Submission on Revised Application for 2,4,6,8,10,12,14,16 Pockley Ave, Roseville

Project ID: SSD-77825469

04.03 Building Basement 01 Floor Plan - Vehicle Entry On Maclaurin Parade

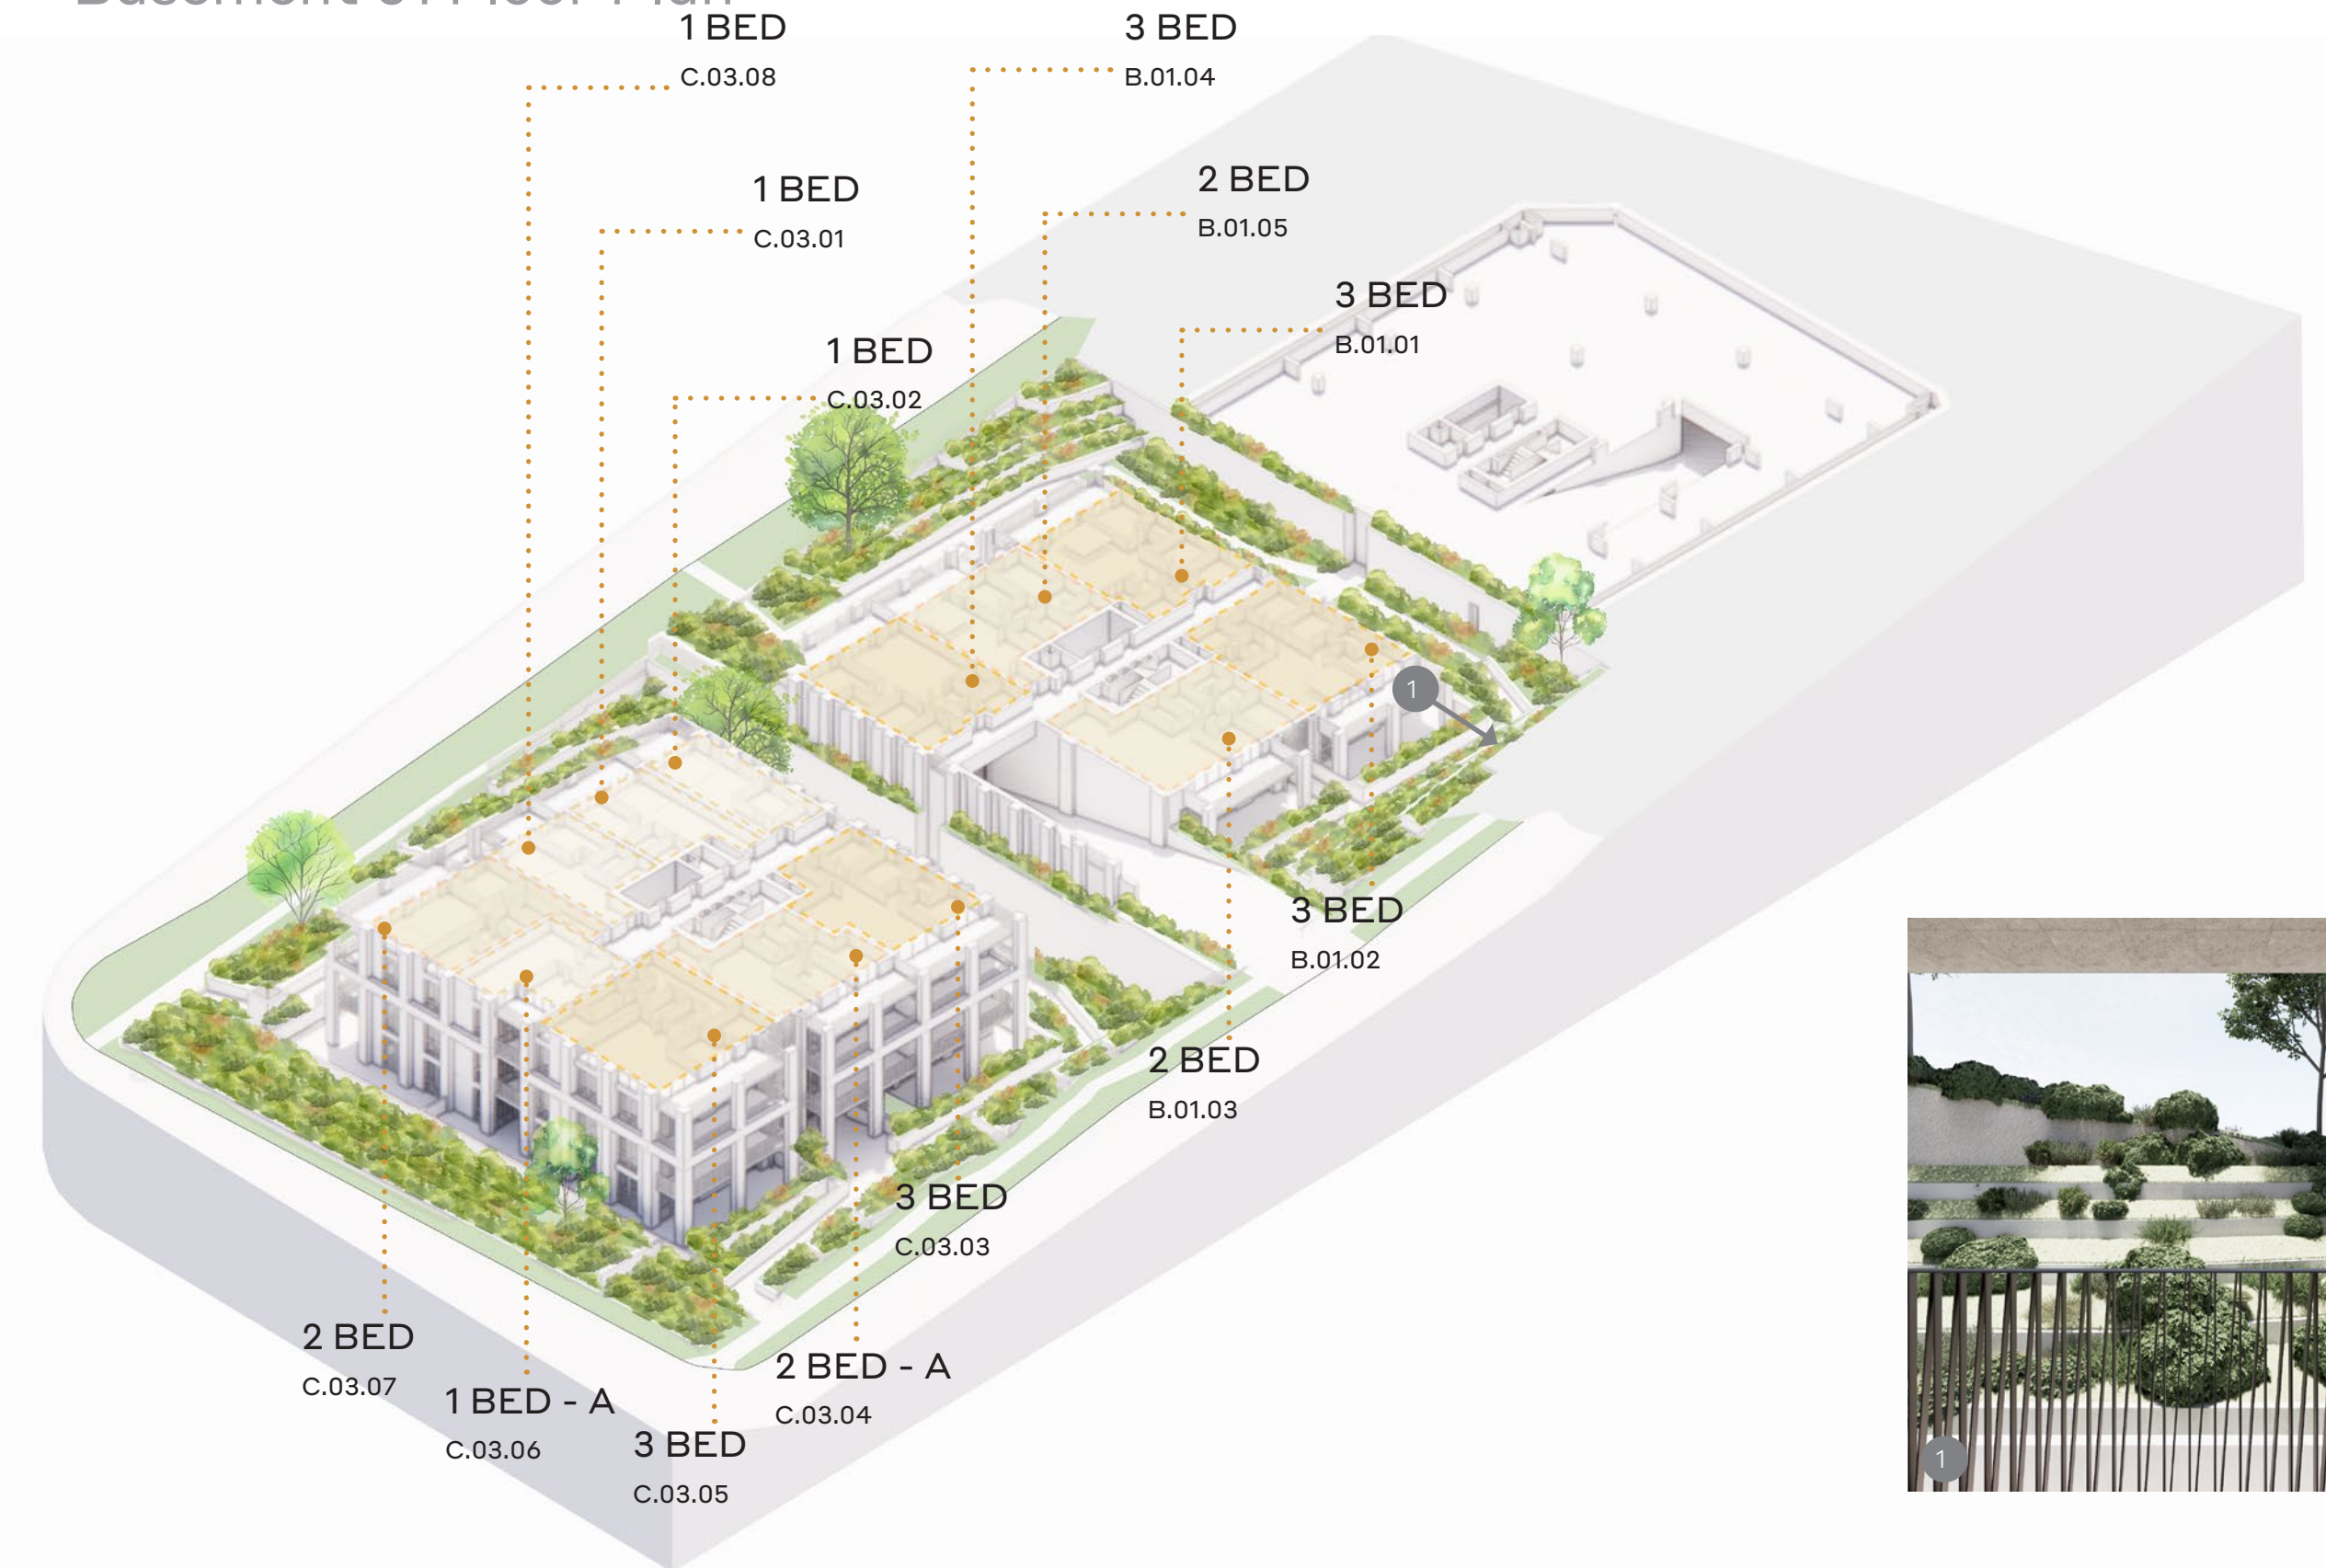
The development vehicle entrance is at the intersection of MacLaurin Parade and Nola Road where there is a bend in MacLaurin Pde. The road narrows to two lanes at this intersection.. With parked cars, MacLaurin Pde has one trafficable lane. The left downhill lane slopes significantly towards the Nola Road level. Cars exiting left will have little vision of downhill traffic until well out of the exit to MacLaurin Parade as shown in Figure 5. For a vehicle exiting, the parked cars adjacent to the exit and the bend in MacLaurin will severely hamper visibility of vehicles descending MacLaurin Parade **thereby promoting accidents**.

Action: Redesign to have the vehicle entrance in Pockley Avenue to remove the accident promoting arrangement.
